## NSW RURAL FIRE SERVICE

Your reference: SSD-17647189  
Our reference: DA20210424001613-EIS & DA  
Exhibition-1

**State Significant Development - Warehouse or Distribution Centre  
Request for comments - exhibited Environmental Impact Statement (EIS)  
SSD-17647189 884-928 Mamre Road Kempers Creek NSW 2178, 52//DP259135**

LOT 2 - Site Plan / Ground Floor Plan / Fencing Plan

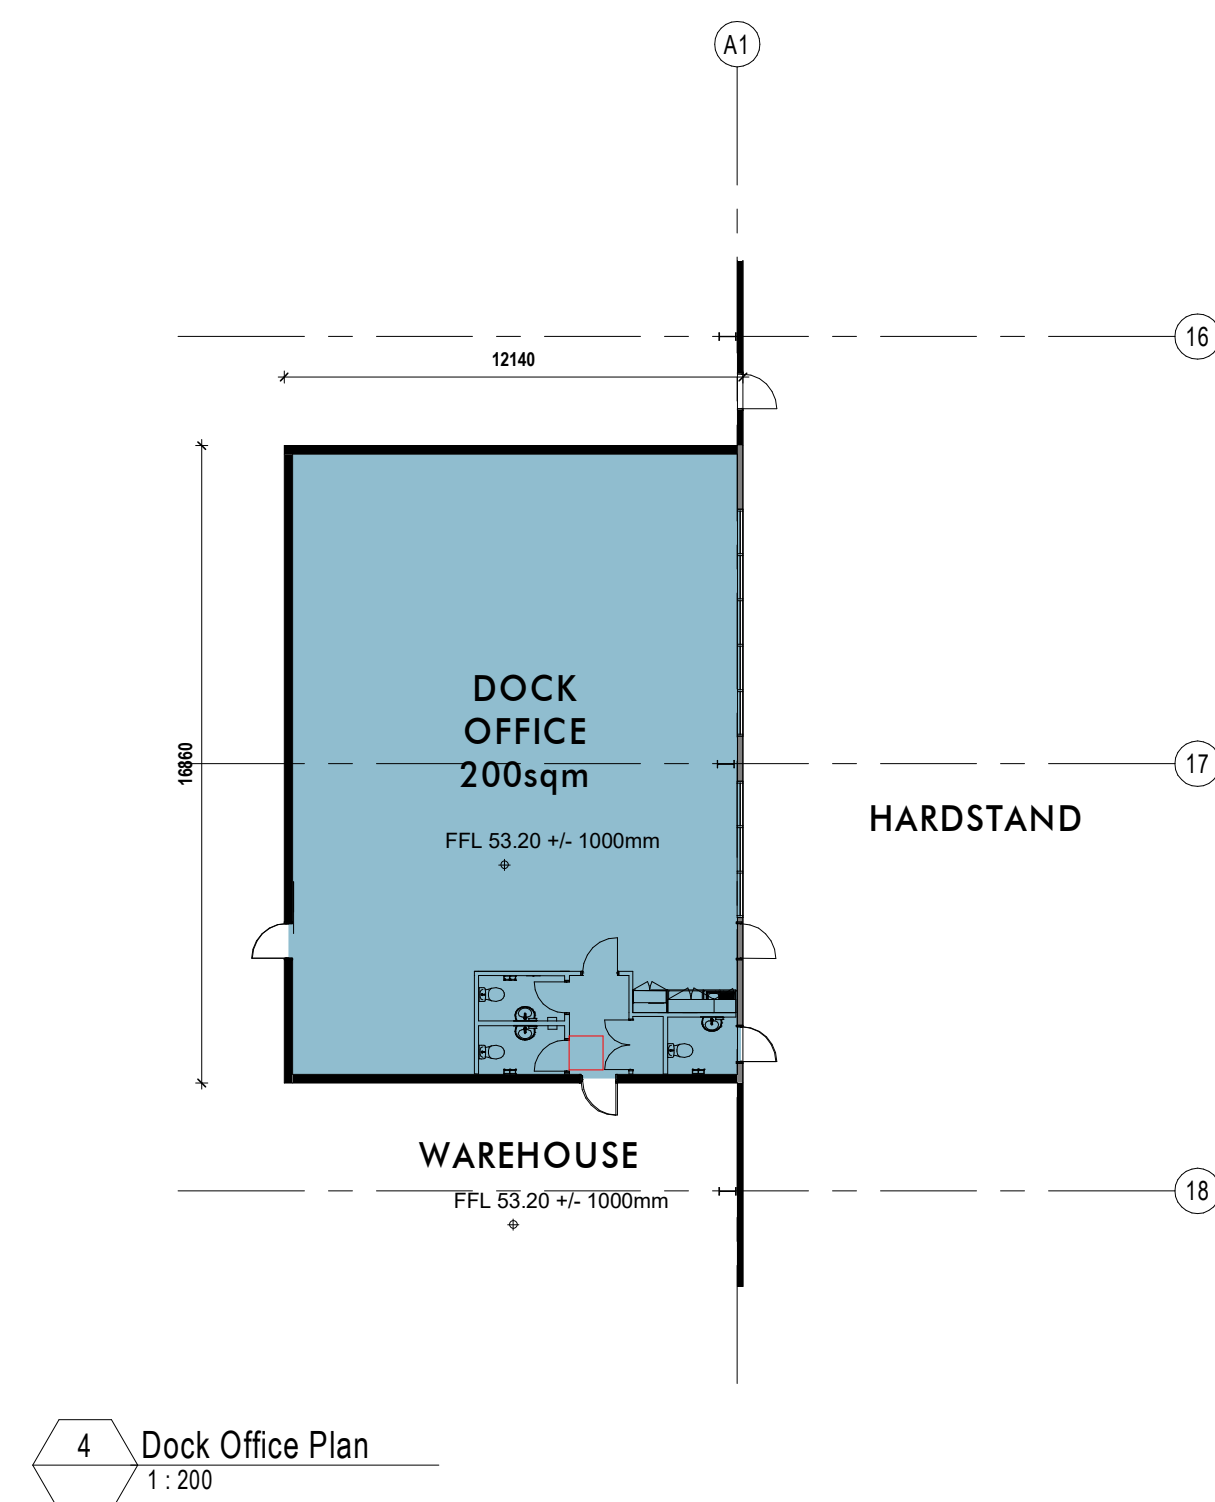
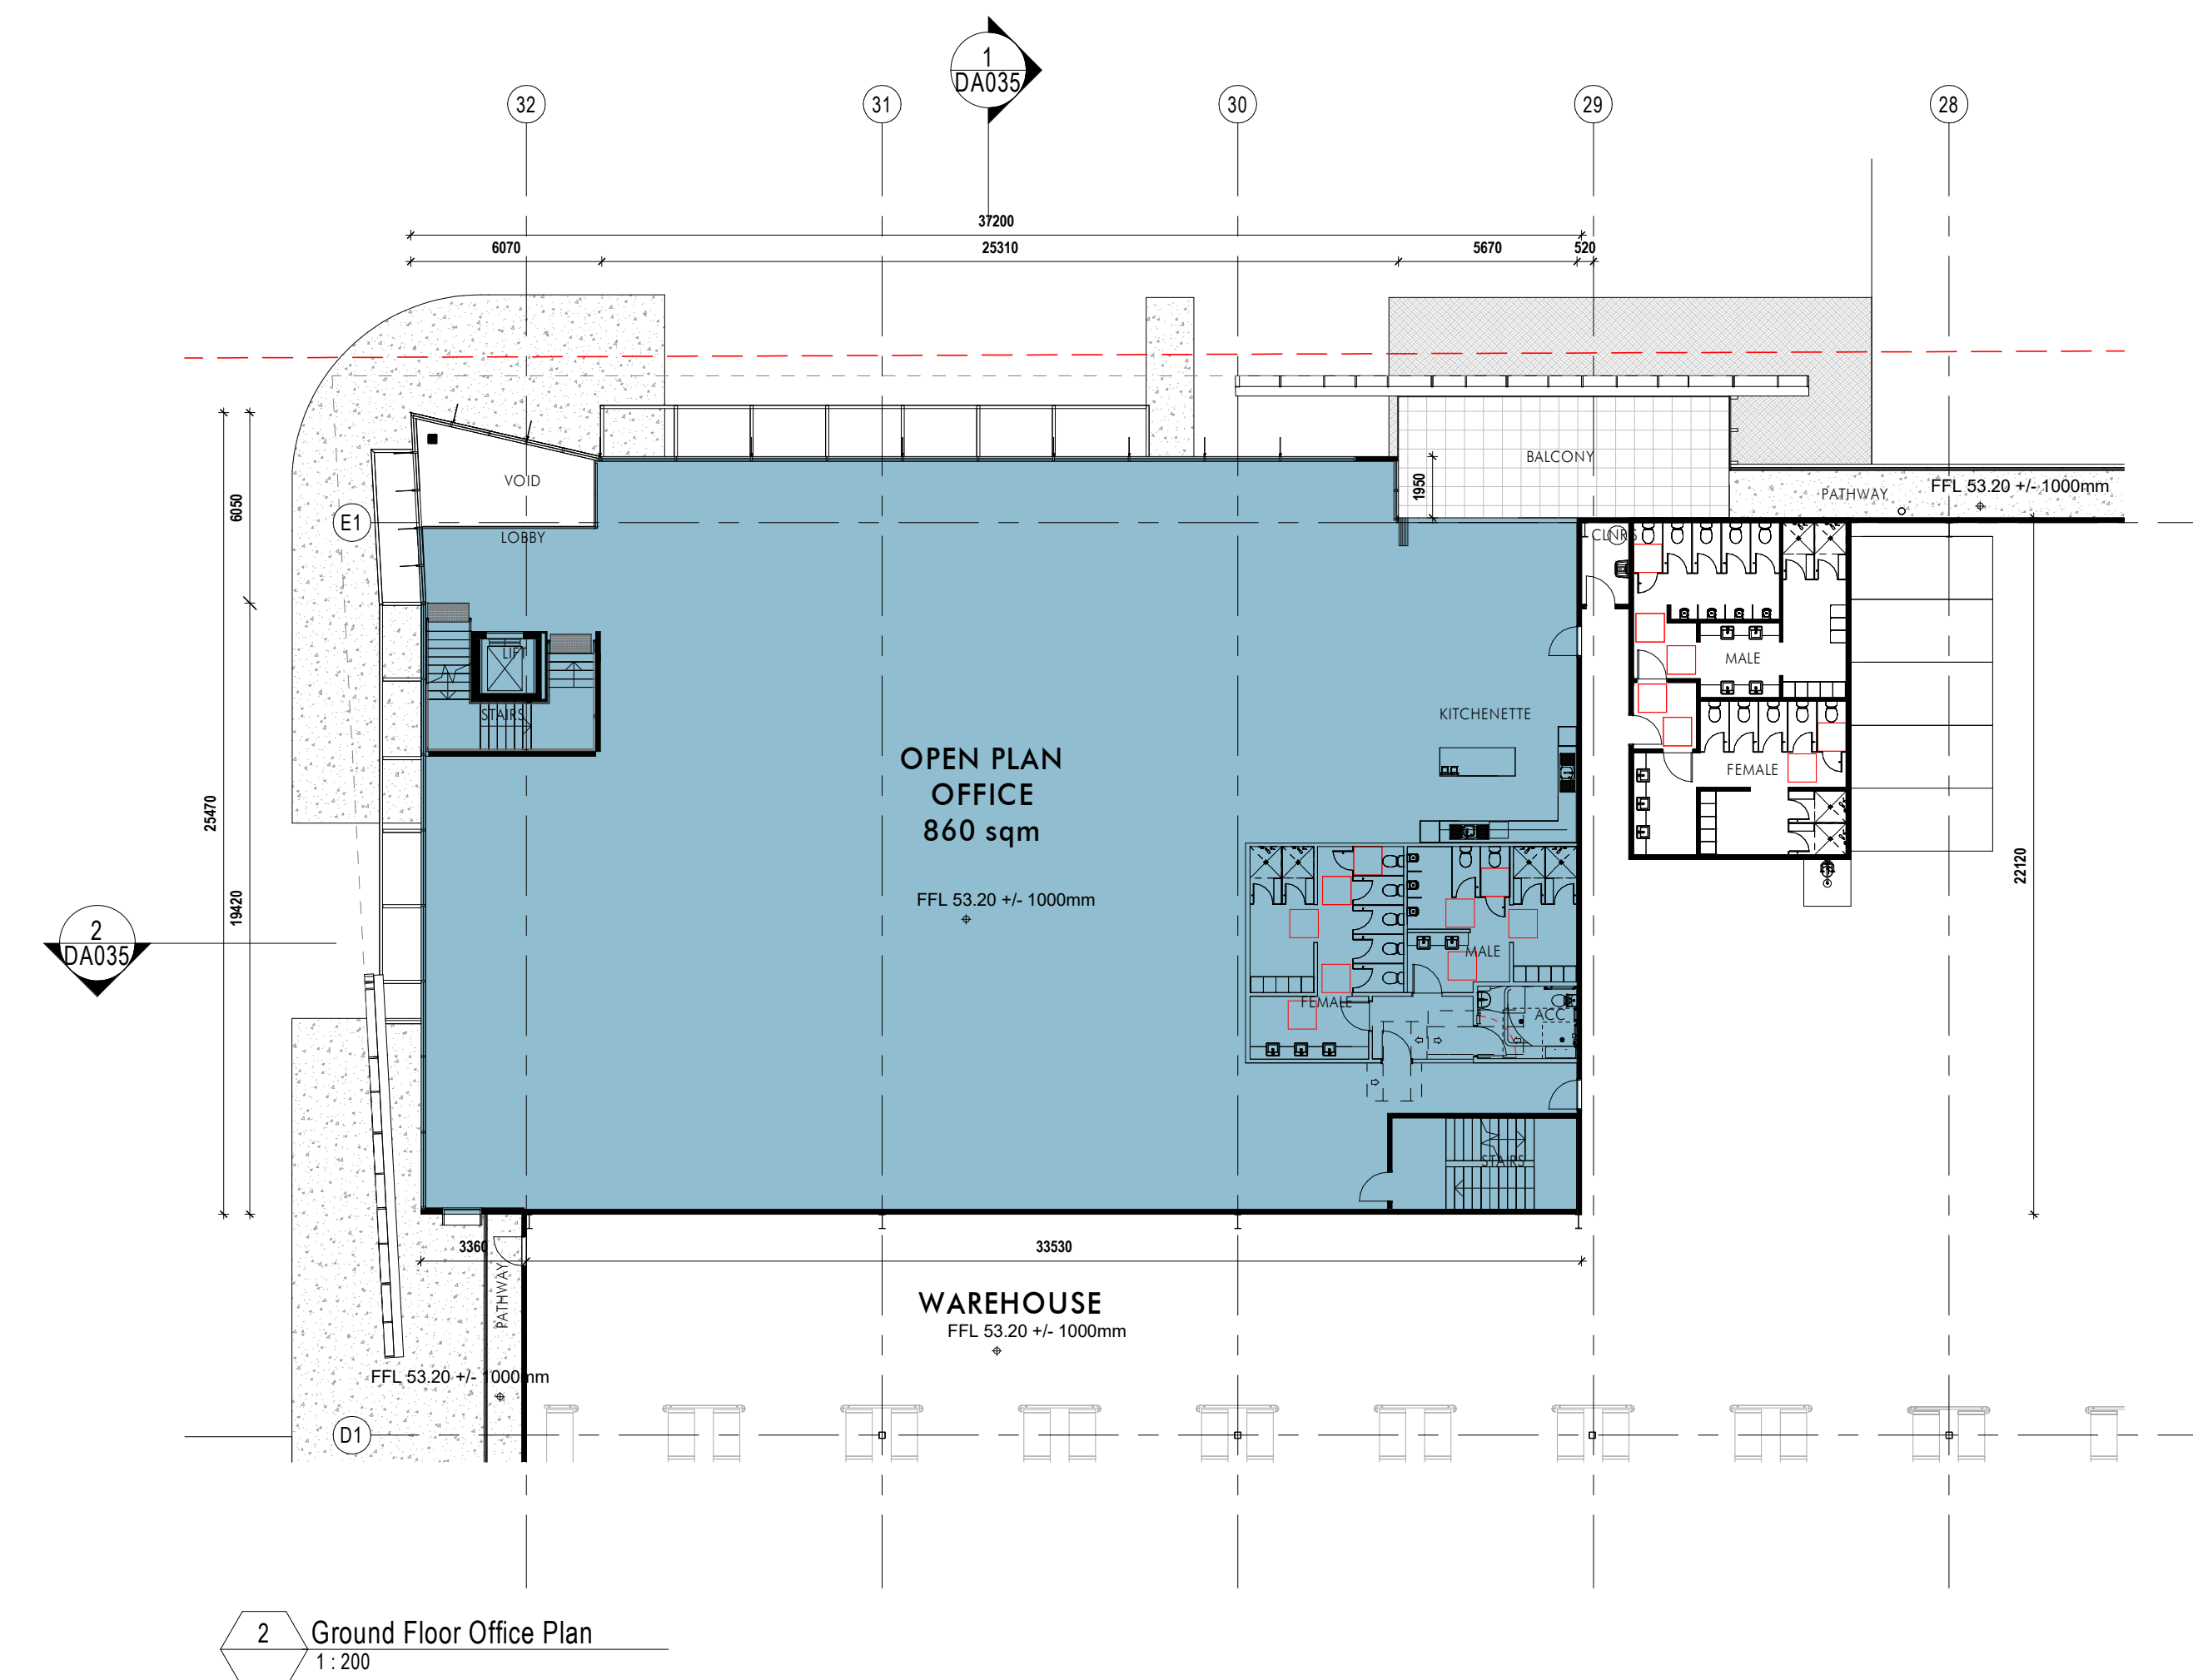
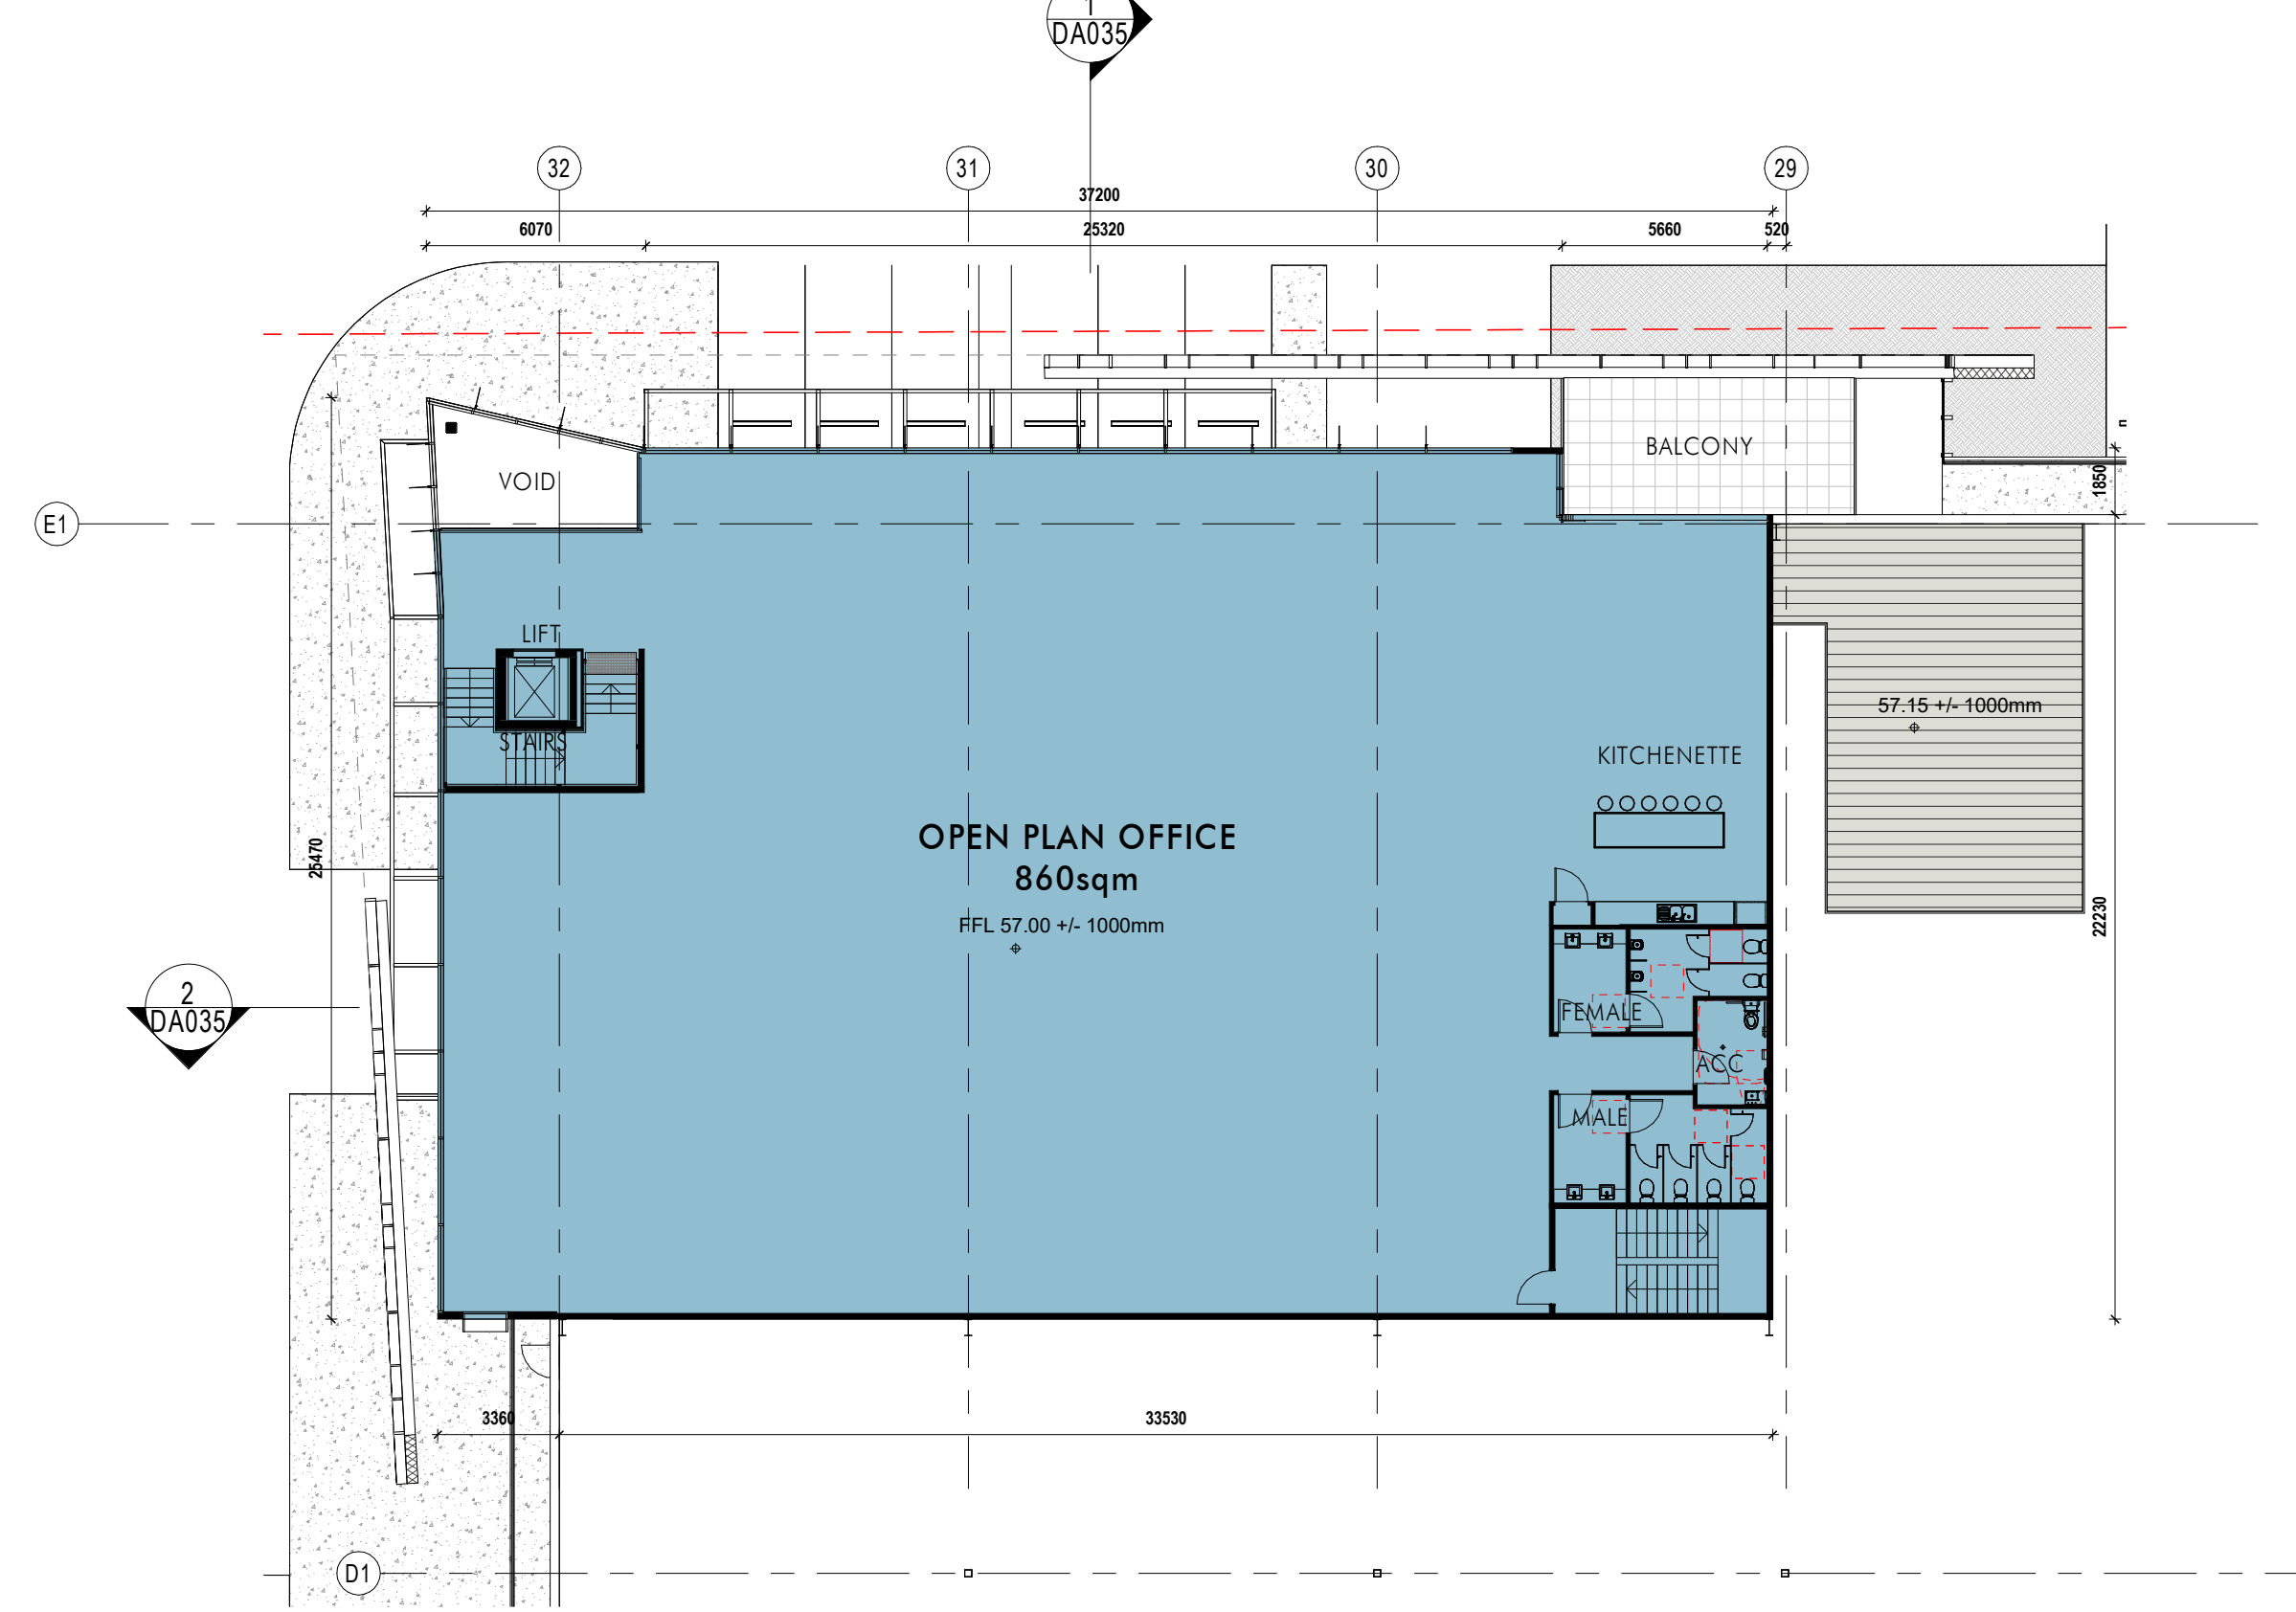
1. All lots (except for Lot 3 road dedication and the bio-retention basin/s) must be managed in perpetuity as an inner protection area (IPA) in accordance with the requirements of Appendix 4 of *Planning for Bush Fire Protection 2019*. When establishing and maintaining an IPA, the following requirements apply:

- Tree canopy cover be less than 15% at maturity;
- Trees at maturity are not touching or overhang the building;
- Lower limbs are removed up to a height of 2m above the ground;
- Tree canopies are separated by 2 to 5m;
- Preference is given to smooth-barked and evergreen trees;
- Large discontinuities or gaps in vegetation are provided to slow down or break the progress of fire towards buildings;
- Shrubs are not located under trees;
- Shrubs do not form more than 10% of ground cover;
- Clumps of shrubs are separated from exposed windows and doors by a distance of at least twice the height of the vegetation.
- Grass to be kept mown (as a guide grass should be kept to no more than 100mm in height);
- Leaves and vegetation debris are removed; and
- NSW Rural Fire Service's document *Standards for asset protection zones*.
